**KIRKLEES METROPOLITAN COUNCIL
INVESTMENT & REGENERATION SERVICE**

DELEGATED DECISION TO DETERMINE PLANNING APPLICATIONS

Reference No:	2025/62/92462/W
Site Address:	Woodville, Bill Lane, Wooldale, Holmfirth, HD9 1XX
Description:	Demolition of existing garage and erection of two storey side and rear extensions
Recommending Officer:	Joshua Merriman

HOUSEHOLDER DELEGATED REPORT

DRAWING TITLE
 PROPOSED SITE PLAN

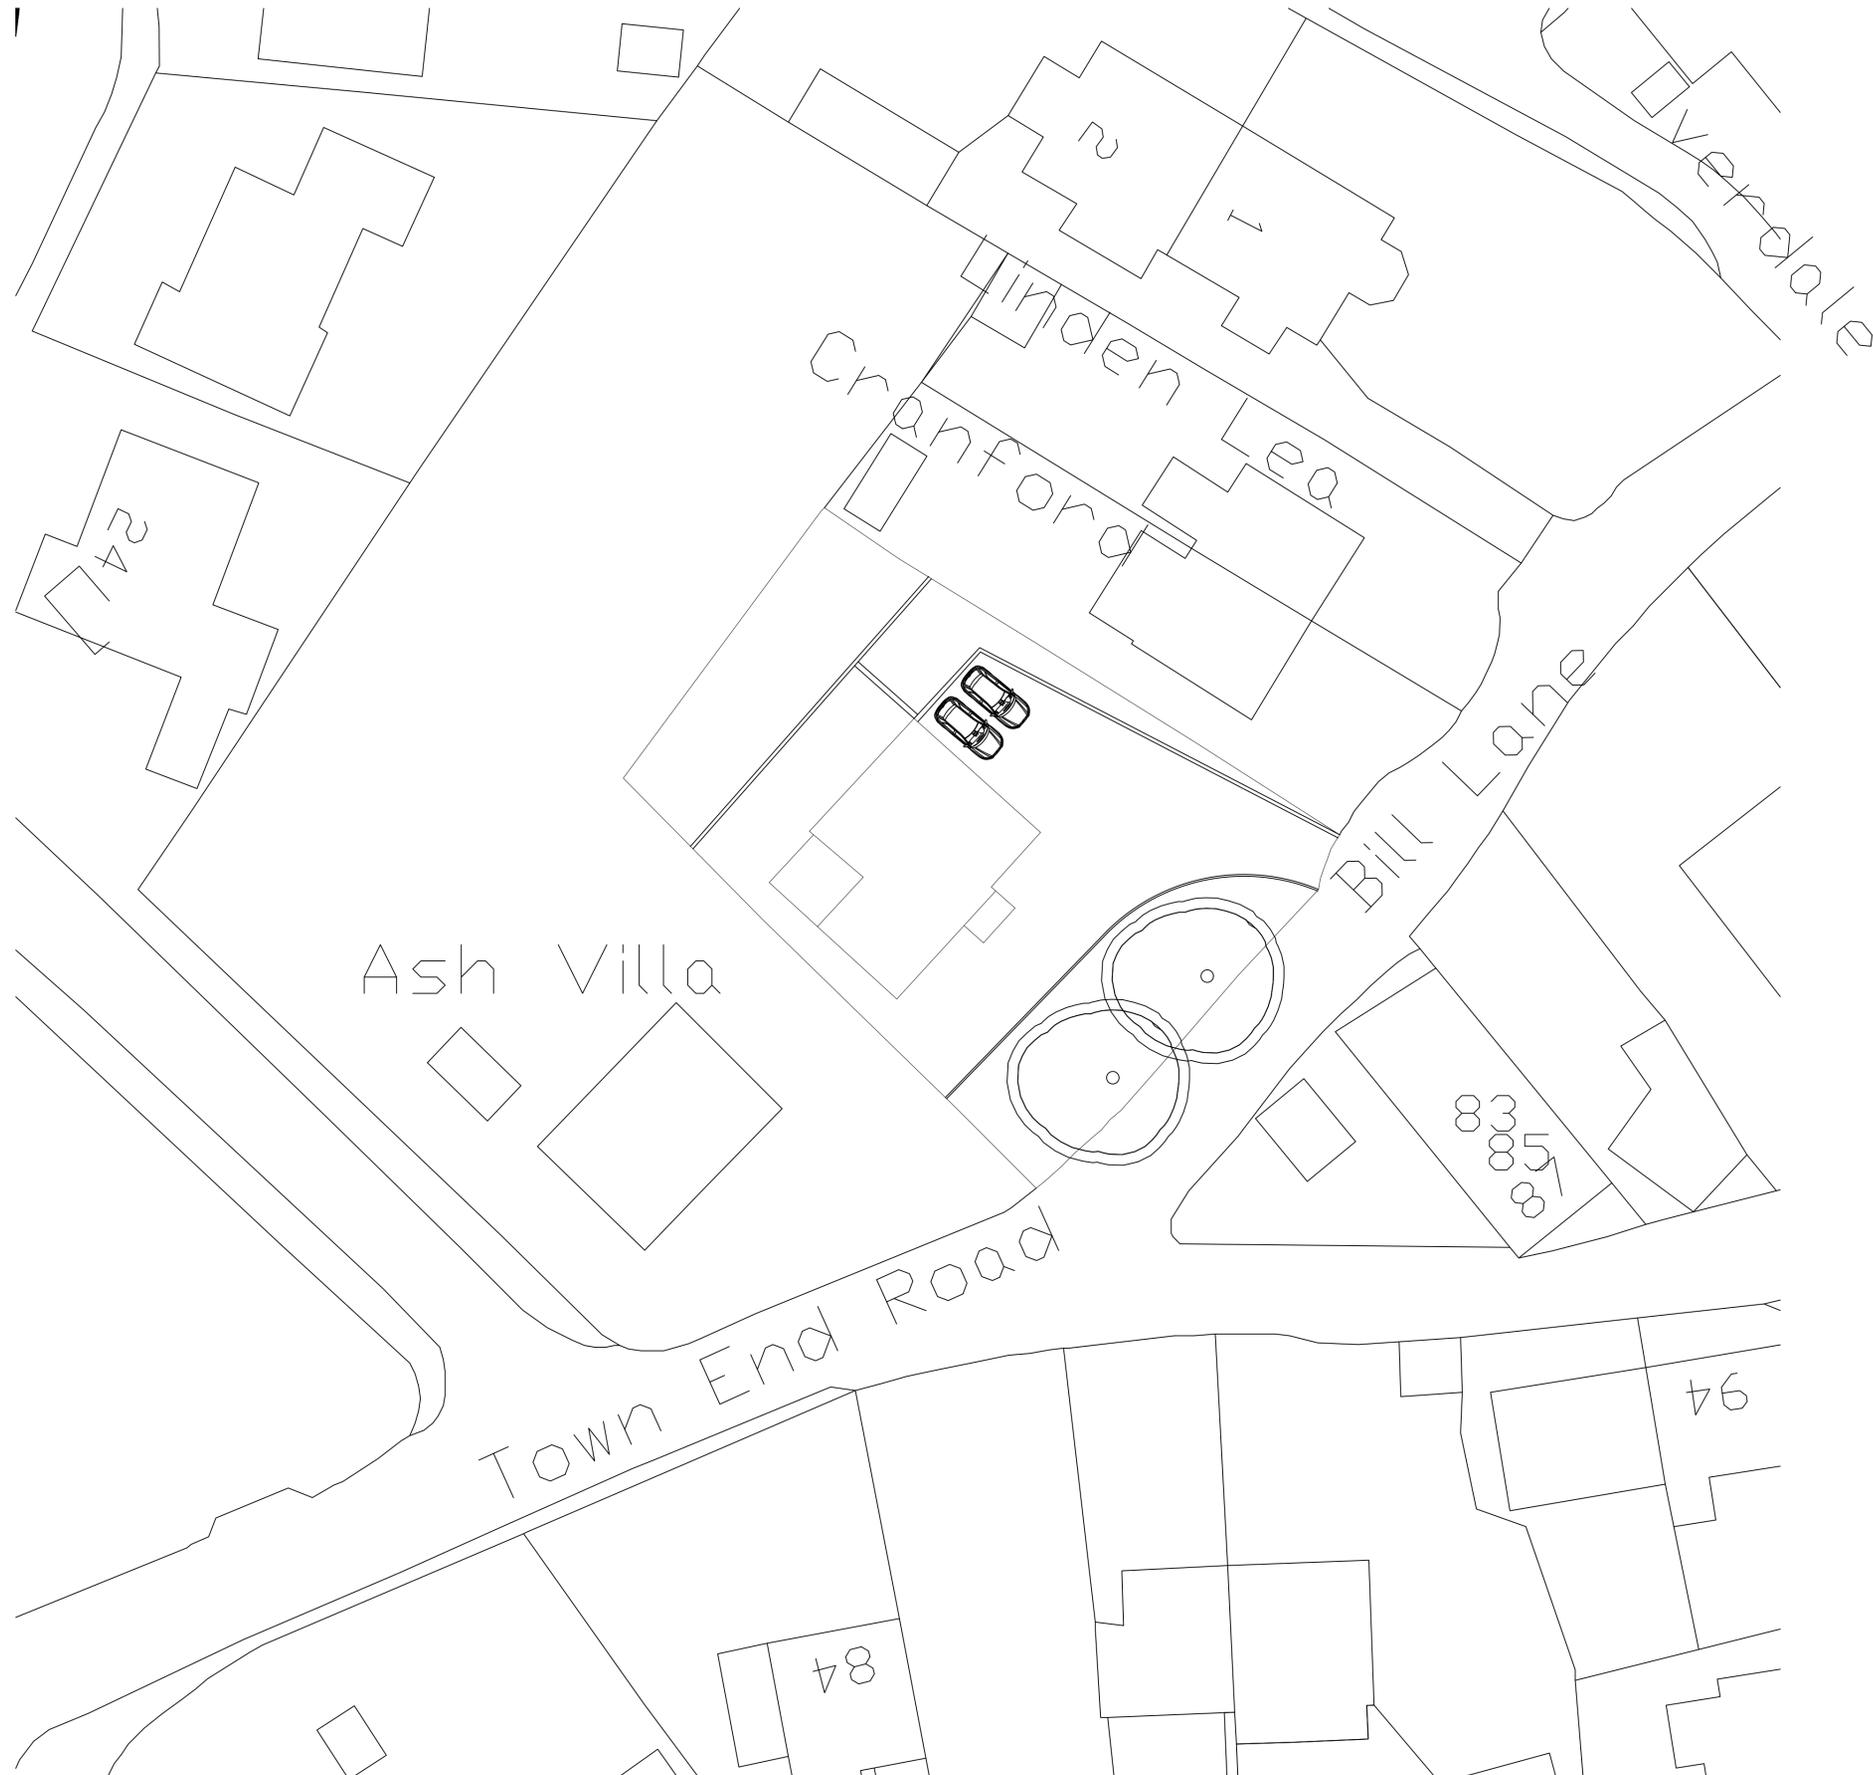
Side extensions should:	<u>Yes - COMPLY</u>	<u>No - JUSTIFY</u>
Ensure reasonable levels of natural light to the habitable rooms in neighbouring properties	The application property is located an adequate distance away from neighbouring dwellings for there to be no significant impact upon the levels of natural light to habitable rooms in neighbouring properties.	
Positioning windows to minimise or avoid any potential overlook into neighbouring gardens	As there are no first-floor windows proposed in the side elevations, and the windows to the rear and front are not considered to have any additional impacts than the windows existing in the house, it is considered that there will be no significant impact with regard to overlooking.	
Two storey side extensions should:		
Not take up all or most of the space to the side of a house	Space will remain to the side of the property.	
maintain a 1 metre gap to the side boundary to ensure the building is not too close to a neighbouring property	A gap of at least 1m will be retained to all surrounding property boundaries.

elevation of the dwelling.	
Rear extensions should:	<u>Yes - COMPLY</u>	<u>No - JUSTIFY</u>
Preserve a back garden of a reasonable size, with a general principle that at least half the garden area is retained	At least 50% of the current garden space on site will be retained.	
Be set behind the original building, and not projecting beyond the sides	The extension will be completely set behind the existing building, not projecting beyond the sides.	
Maintain external access to the rear garden	The current external access to the rear garden via the North East of the dwelling will be retained.	
Respect the original house and garden in terms of its size and scale	The extensions are subservient to the existing building and respect the application site and garden.	
Use appropriate materials which match or are similar in appearance to the original house	All materials used will appear sympathetic to the existing building and surrounding area.

Remaining garden space of application property	<ul style="list-style-type: none"> • KDP 7 of the SPD • Policy LP24 Design (b) and (c) • Chapter 12 of the NPPF 	At least 50% of the current garden space on site will be retained, which is considered to be acceptable.	✓
--	--	--	---

DRAWING TITLE  
 PROPOSED ELEVATIONS

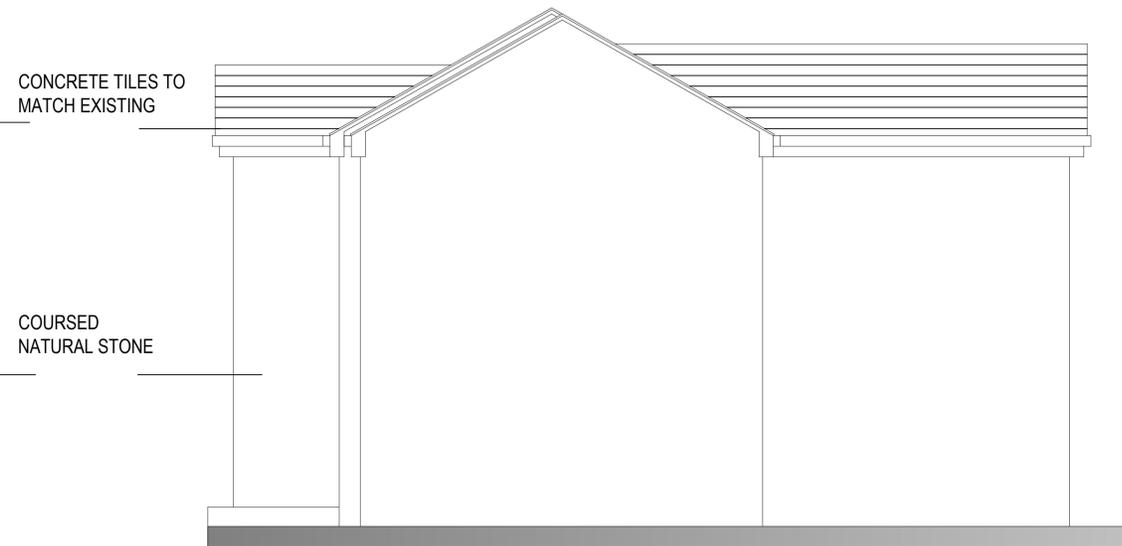
The proposed side extension will project 4.33m from the side elevation of the existing building, with a maximum height of 7.84m, eaves height of 5.2m, and a depth of 5.67m.

The proposed rear extension will project 4.36m from the rear elevation of the existing house, with a maximum height of 6.8m, eaves height of 5.22m, and a width of 6.78m.

The use of white 'K' render as a primary material in the development is considered acceptable and sympathetic due to its presence in the street scene and prominence among neighbouring properties to the North East of the application site.

It is also noted that a two-storey front projection is proposed on the submitted plans, and due to the varied nature of the street scene, presence of gable front extensions in the local area, and use of sympathetic or matching materials, this is also considered acceptable with regard to visual amenity.

3. The external walls of the extensions hereby approved be white/off white 'K' render with brick/stone as shown on drawing reference 2557 05 and thereafter be retained.
